DRB CASE ACTION LOG (SITE PLAN B.P.)

DRB Application No.: <u>07DRB-00083 (SBP)</u>	Project # <u>1005310</u>
Project Name : <u>RENAISSANCE CENTER</u>	
Agent: <u>Gregory T Hicks & Associates</u>	Phone No.: <u>243-7492</u>

1. Project # 1005310
07DRB-00083 Major-SiteDev Plan BldPermit

GREGORY T HICKS & ASSOCIATES agent(s) for STEVE GRIEGO request(s) the above action(s) for all or a portion of Tract(s) 9-C, **RENAISSANCE CENTER**, zoned SU-1 FOR IP, located on CHAPPELL DR NE, between MISSION DR NE and RENAISSANCE BLVD NE containing approximately 1 acre(s). [REF: 06AA01769, DRB-96-495, V-96-110] (F-16)

proj. no.: 0614  
 ocad file:  
 date:  
 EXTERIOR ELEVATIONS

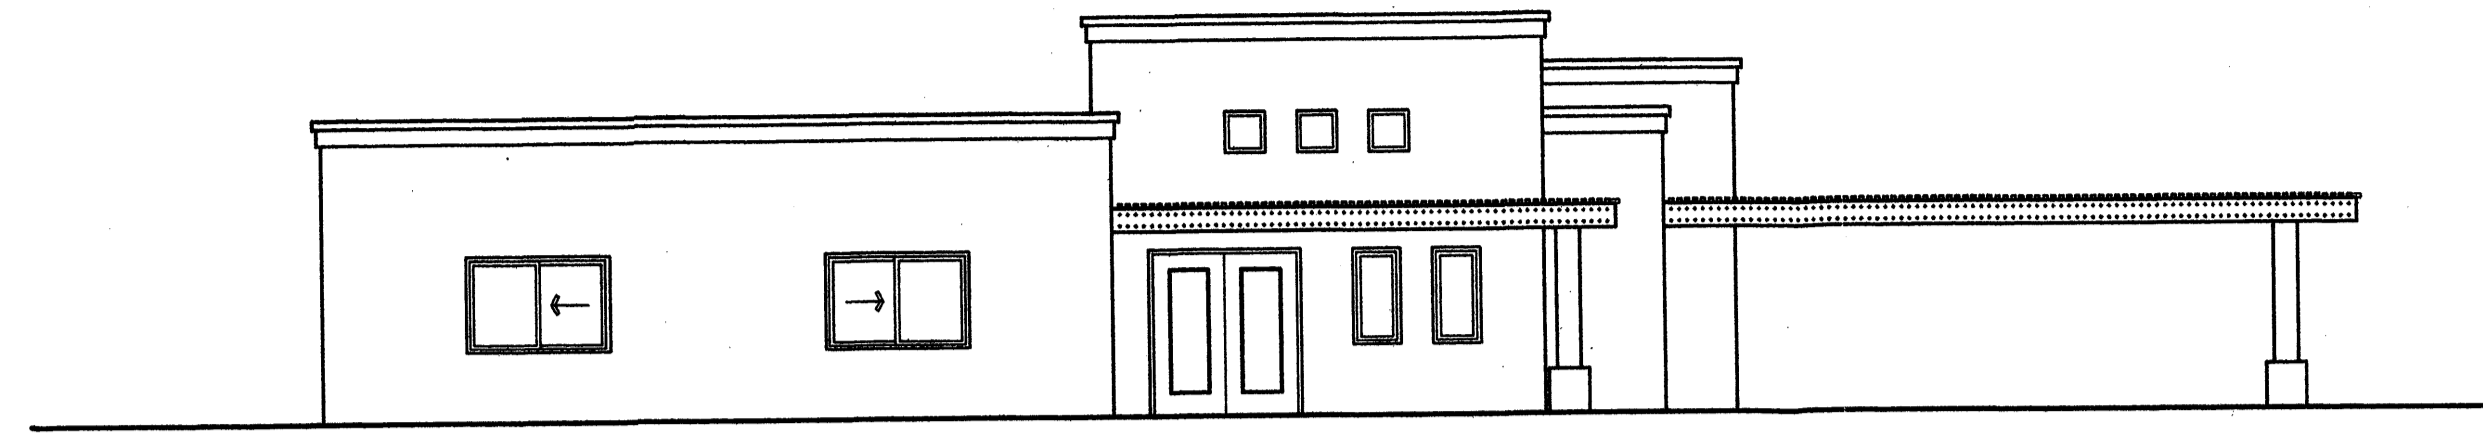
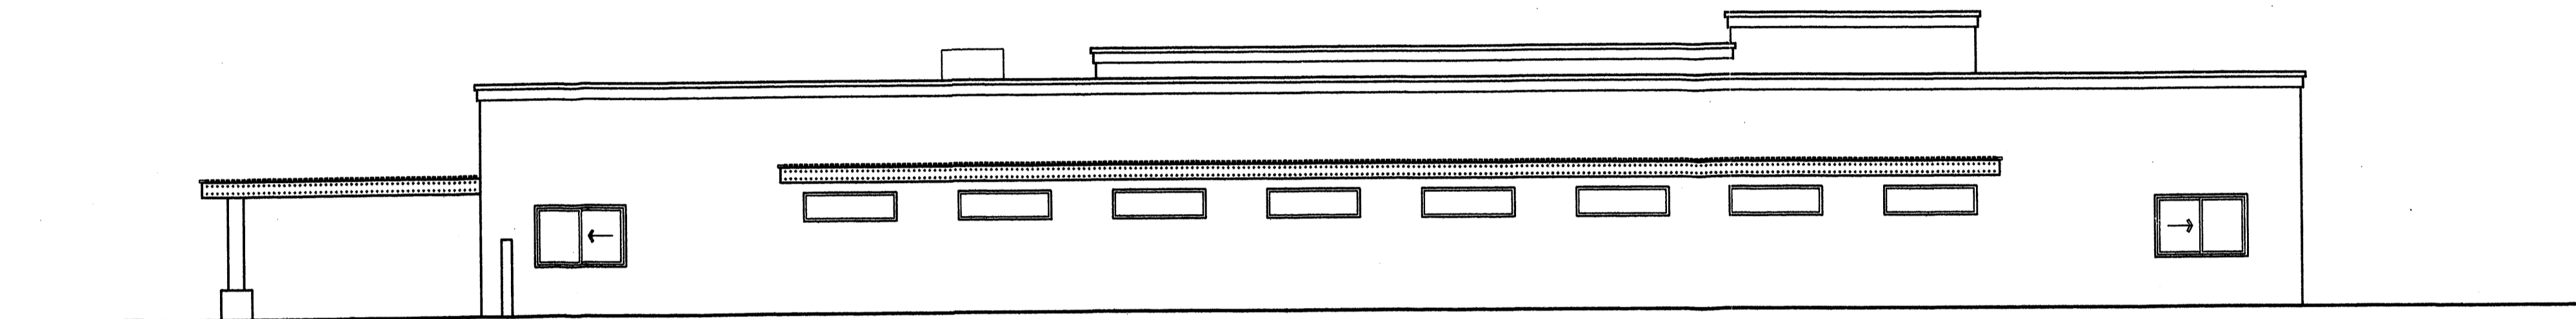
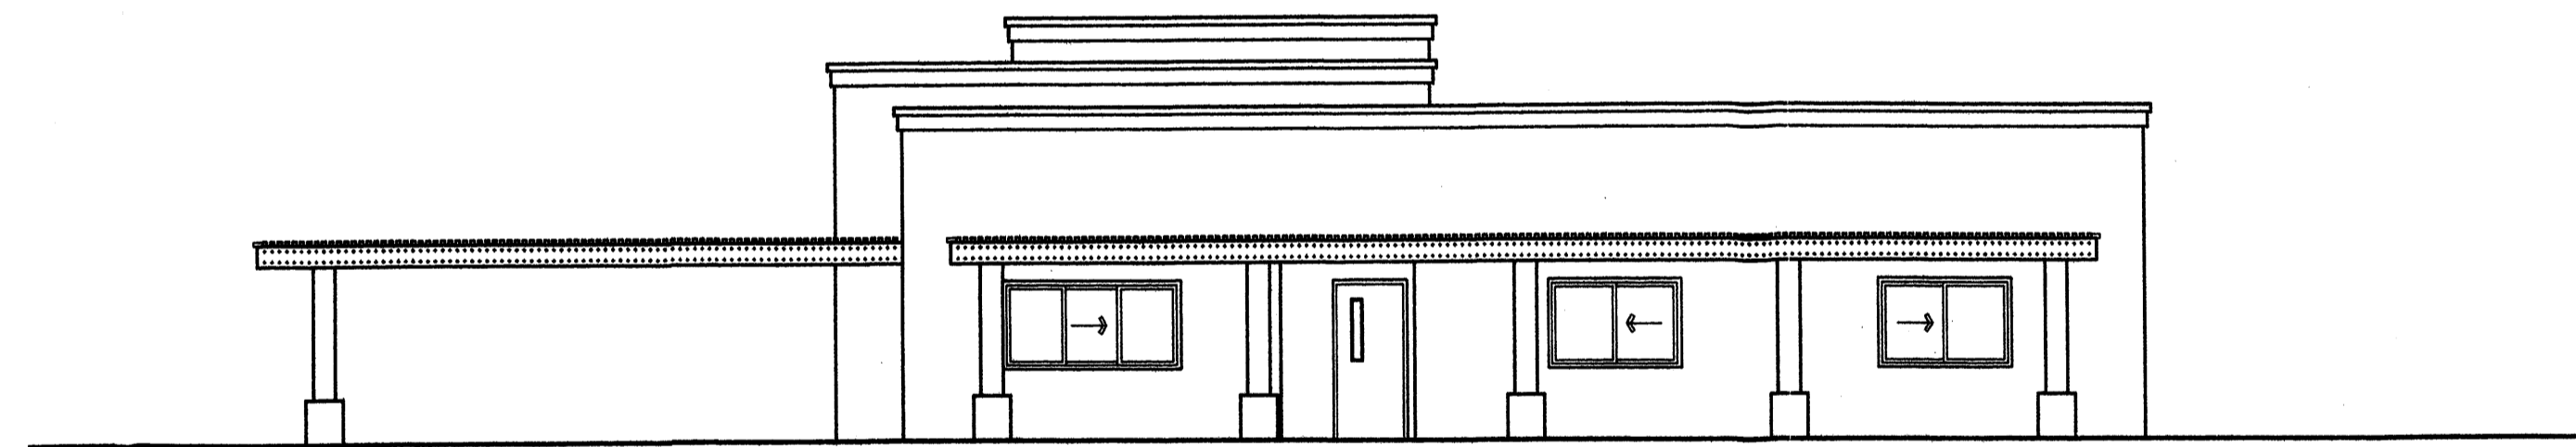
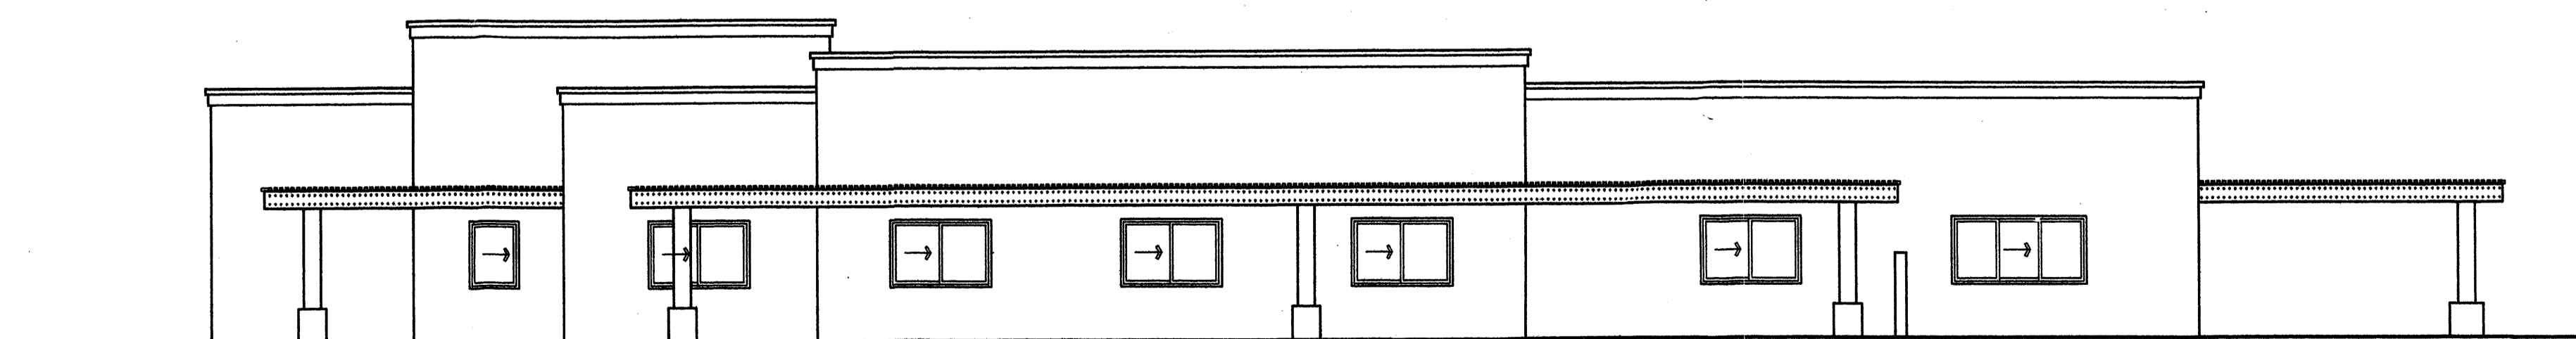
The overall width of the building appears to be missing from the Elevations sheet.
